**Planning Officer:** Michael Eastham

**Planning Application Ref:** A/70/18/DOC

**Location:** Quiet Waters, Roundstone Lane, Angmering

**Description of works:** Application for approval of details reserved by condition imposed under planning permission A/132/17/OUT relating to condition No. 17 (Tree scheme of protection) & 22 (Contamination risks)

Scale: 1:250@A1	Drawn: AR	Date: 05-01-17
Drawing Number: RCO 193 / 01	Revision: 02

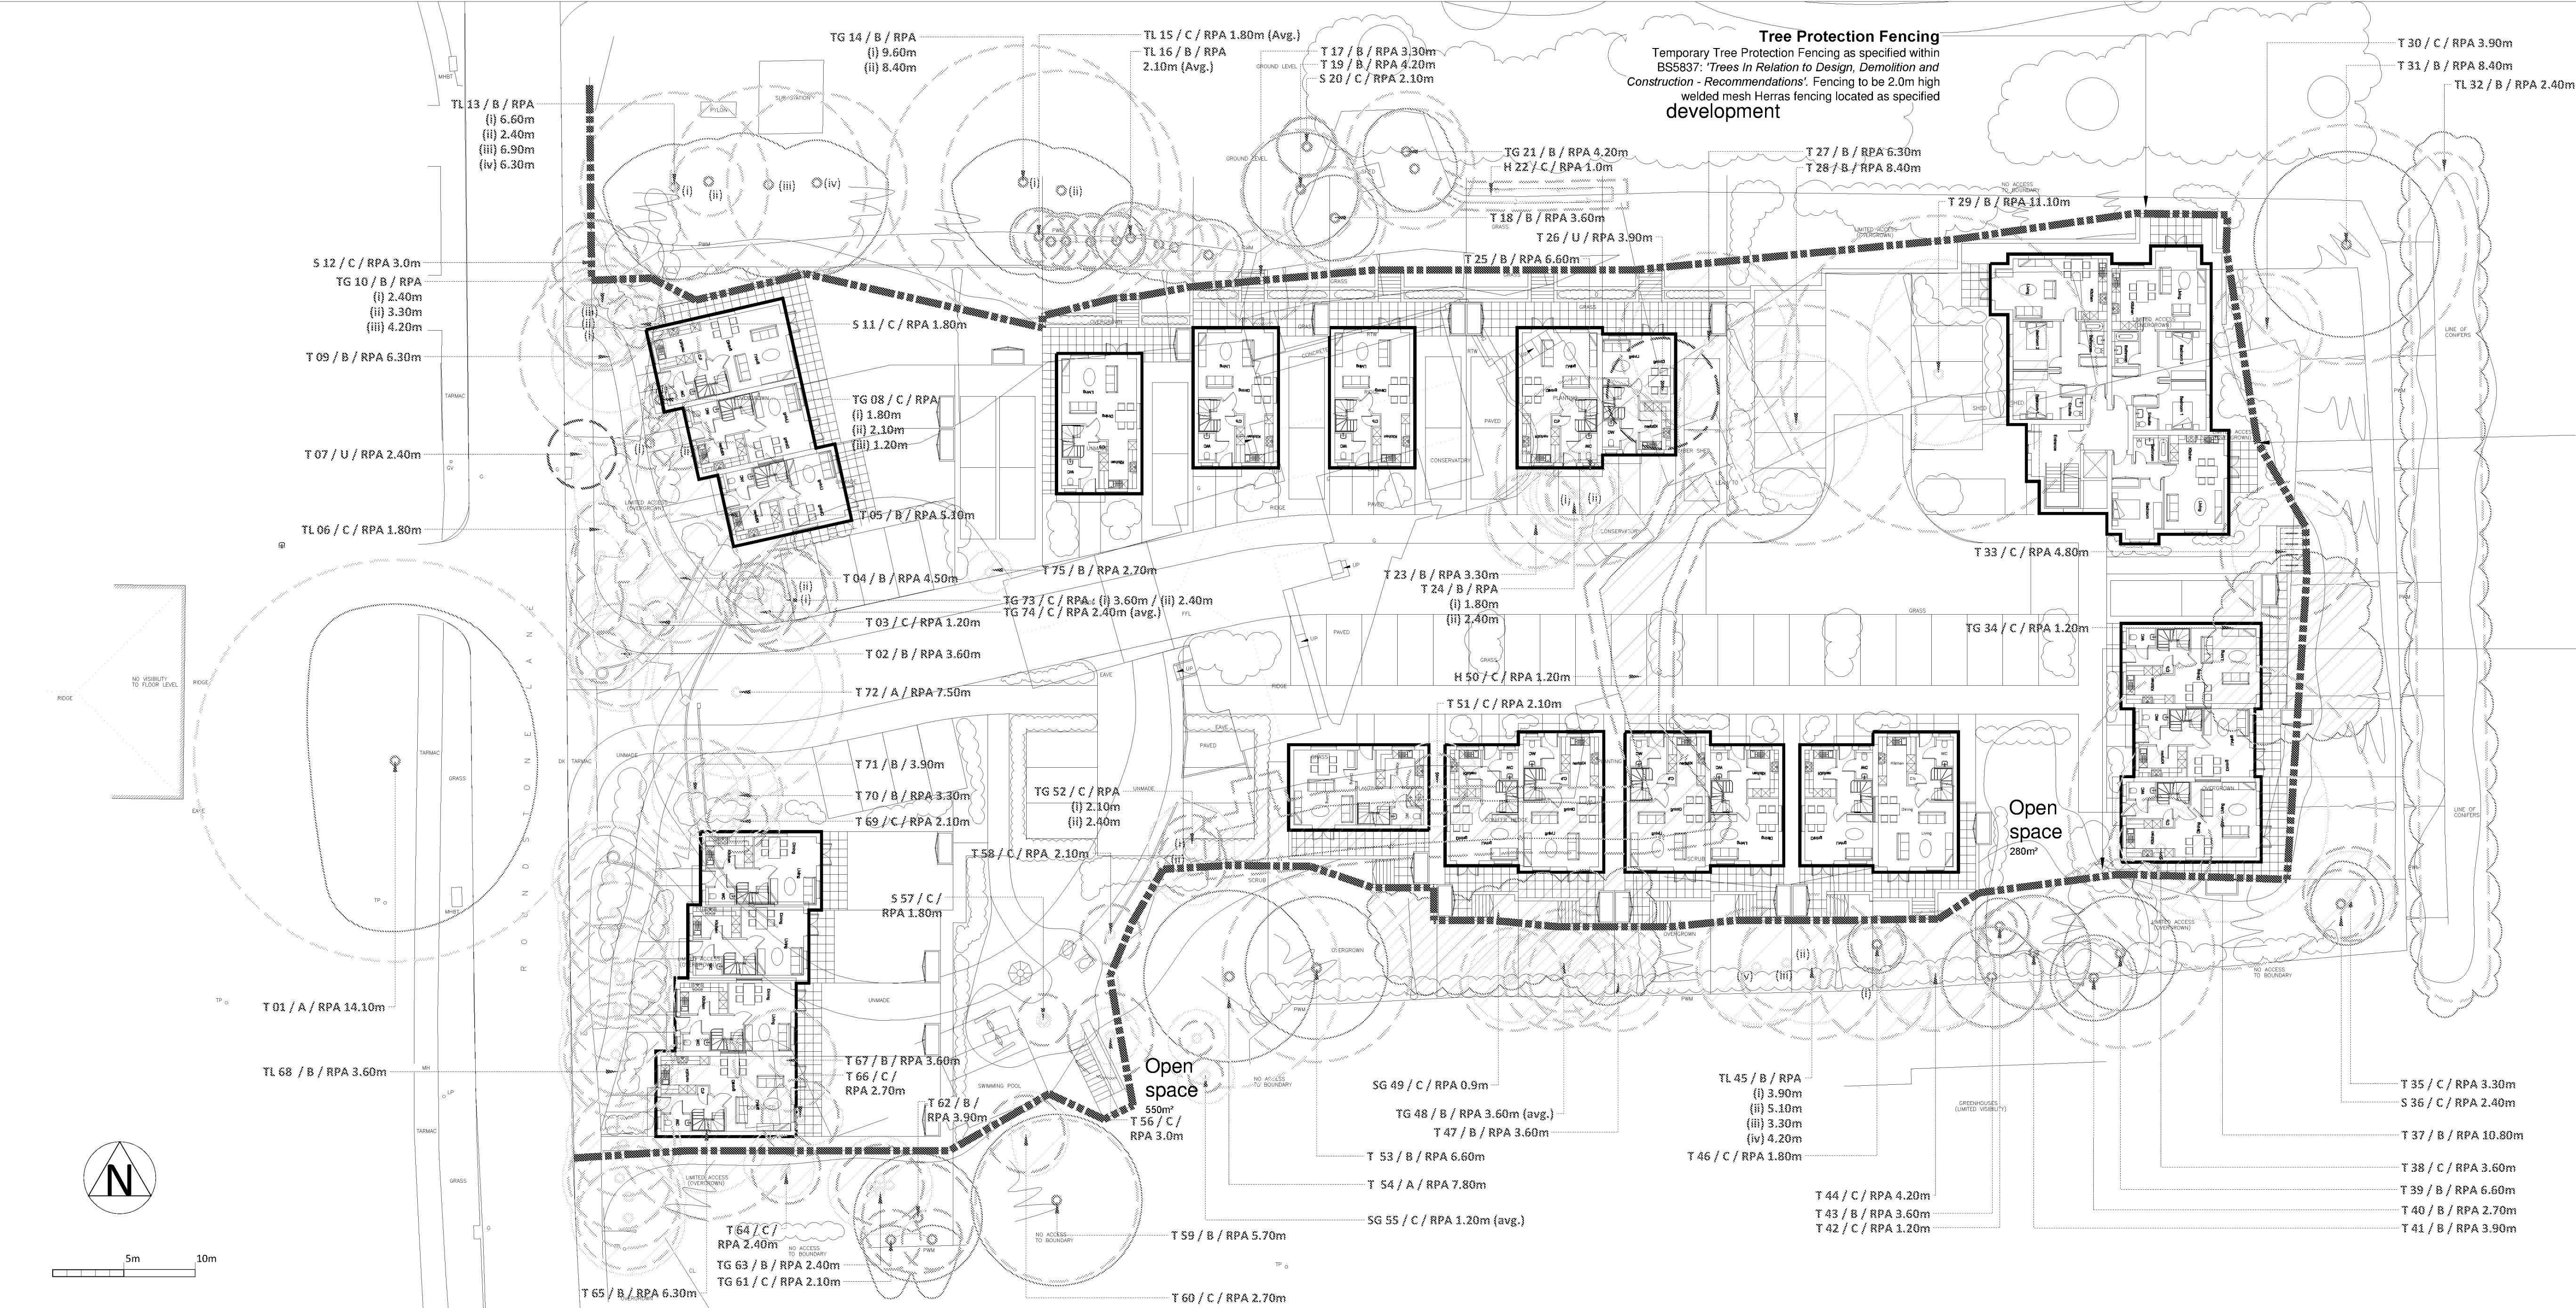
- Drawing No. NJCL 252 C, dated 21.05.2018, from Nicholas Jones Consultants Ltd., submitted in support of A/81/18/RES
  - Drawing No. RCo 193/01 (Rev:02), dated 05.01.2017, from Ramsay & Co Landscape Architecture, submitted in support of A/132/17/OUT

- Both plans appear to specify 'fit for purpose' fencing in similar if not identical position, to effectively form a construction exclusion zone around significant retained trees, as is standard practice and required by BS5837.

- None of the aforementioned fencing has been installed or even brought to site at this time. I attach photographs taken at the time of my inspection.
- Deep excavation has recently been undertaken in connection with underground utility apparatus immediately inside the main site entrance. This does not interfere with the root protection area of trees proposed for long-term retention

- The developer must now install permanent fencing in accordance with their most Tree Protection Plan and as a matter of urgency; to form effective Construction Exclusion Zones so as to adequately respect and protect significant trees on site before any further work occurs.
- As things stand, I am unable to recommend 'signing off' on this part of Condition 17.
